**RE: Level I Site Plan Development Staff Review Response and Revised Plans
Uhaul Facility
425 Marginal Way
Portland, Maine**

On behalf of Uhaul Co. of New Hampshire & Maine, Inc. (Applicant), Walsh Engineering Associates, Inc. (WEA) is pleased to submit this response and updated Site Plans to the staff review comments received on October 16, 2014 for the Level I Site Alteration application for the site alterations to the subject property at 425 Marginal Way in Portland (Map 8, Block A, Lot 5).

Sheet No.:
C2.0

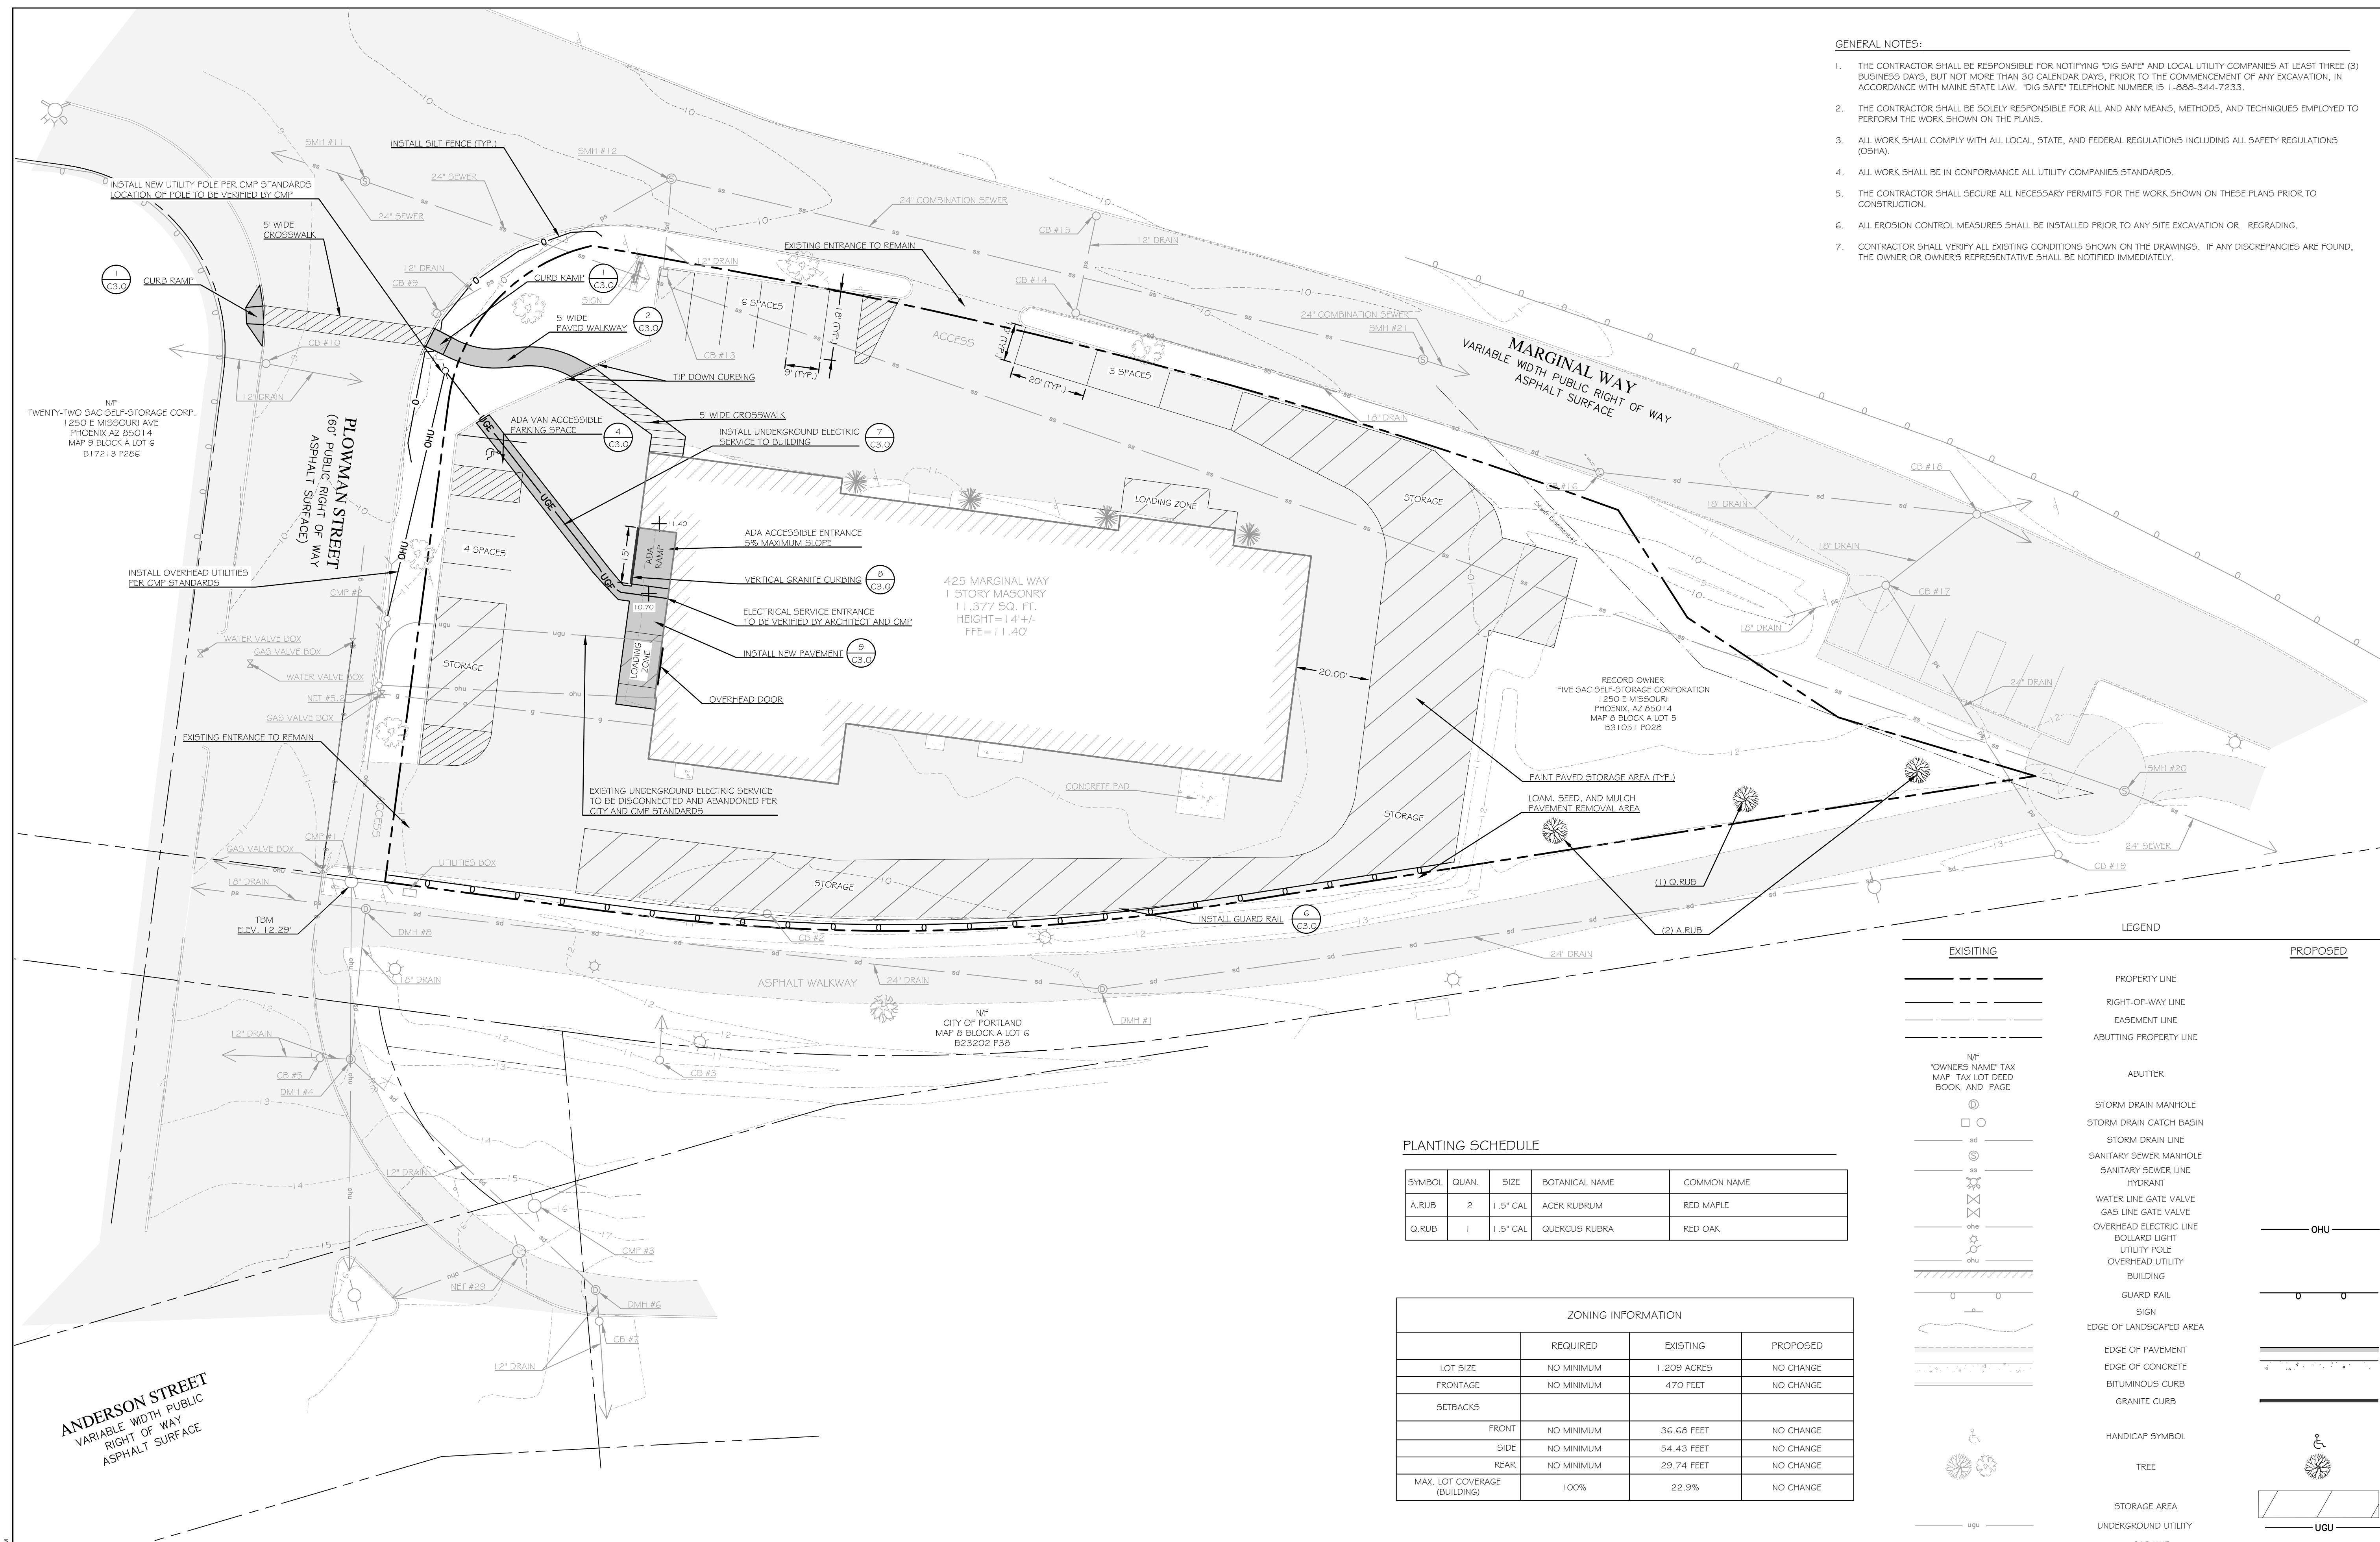
- 1) The proposed crosswalk on Plowman Street should be shifted approximately 15 feet toward Marginal Way. The crosswalk marking shall be "block" design and meet City standards. The sidewalk ramps shall meet City standards and detectible warning panels shall be included.

- 3) All parking circulation aisles shall be 24-feet for two-way flow conditions.

- 4) I would suggest that the parallel parking space nearest the Marginal Way driveway be eliminated (maneuvering in and out of the space may create safety problems).

- 5) I am concerned about entering and exiting vehicle movements at the Plowman Street driveway and how they may create safety issues with Bayside Trail users. The applicant should provide an assessment of this issue and whether any specific strategies should be considered for implementation.

- 2) The 50 foot long guard rail along Marginal Way looks good but I can envision more trailers creeping toward Marginal Way. I believe another increment of guard rail is needed (roughly 15 feet) or if you want to use another barrier such as boulders that would be fine.

- 3) In regard to the boulders on the corner of Plowman and Marginal Way, we'll likely have a condition that they be field located with review and approval by City Staff. There may be a need for additional boulders given the openness of the area and the prolific number of vehicles/trailers in grass areas.

- 4) Tom Errico's last bullet references the Bayside Trail and safety issues at the U-Haul driveway. The new connection shown on the plan to the driveway is compromised by a utility pole and a trail sign. On the other side of the pole it's not much better. We'll need to discuss this further. This may require a field visit with city staff because the plan and google earth does not portray the constraint very well.

- 5) If there is any reference on the site plan regarding the self-storage use obviously that needs to be removed.

The location of the crosswalk has been shifted approximately 15 feet west towards Marginal Way from its originally proposed location.

The crosswalk pavement markings have been revised to 24-inch wide painted lines spaced 4-feet on-center in accordance with the City of Portland Technical Manual.

The vehicular circulation aisle widths have been increased to 24 feet around the building.

The parking space nearest the Marginal Way entrance driveway has been eliminated and 12 feet of clear space has been provided between the entrance and the first parallel parking space. As a result, the total number of proposed parking spaces has been reduced to 12, which is the minimum allowable per the City Ordinance.

We have proposed the installation of “right turn only” and “no left turn” signs at the Plowman Street exit. This strategy will prevent vehicles exiting the facility from crossing the Bayside Trail, but will still allow for connection between the two Uhaul facilities, which is the primary reason for maintaining the Plowman Street access point.

The guard rail along Marginal Way has been extended approximately 20 feet to the north.

Understood. Three additional boulders have been added to the plan on the east side of the proposed sidewalk. A note has been added to Sheet C2.0 indicating that the placement of boulders shall be field located with review and approval by City staff.

WEA visited the site following receipt of this comment to determine an adequate location for a connection to the Bayside trail from the Uhaul facility on the north side of Plowman Street. It appears that there is adequate space on the north side of the utility pole to provide the connection between the pole and the associated guy wire. The site plan has been revised to show the connection at this location and a photograph of the area is included with this submission.

All references to self-storage have been removed from the plans. Please note that the references to self-storage in paragraphs 1 and 3 of the original application cover letter dated September 17, 2014 should be disregarded.

6 GUARD RAIL SECTION
C3.0 NOT TO SCALE

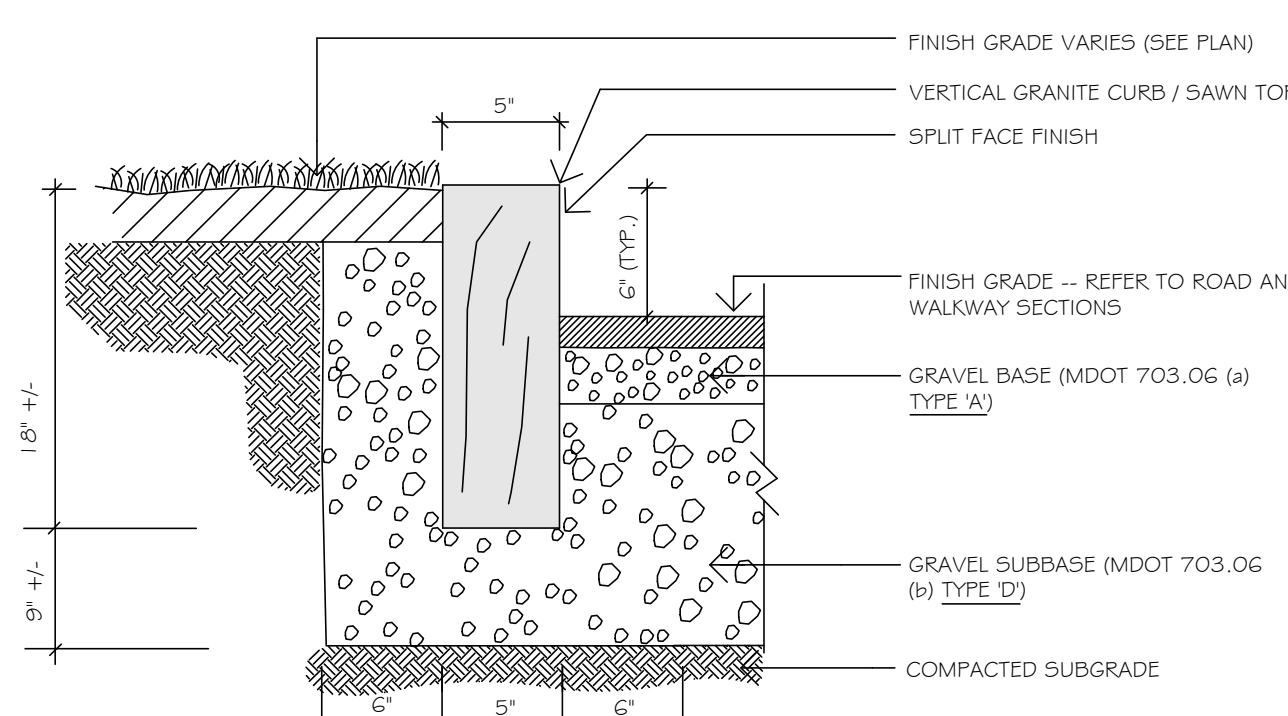
- 1) Guard rail should indicate material of the rail.

Detail 6 on Sheet C3.0 has been revised to indicate pressure treated wooden guard rail posts and rail materials.
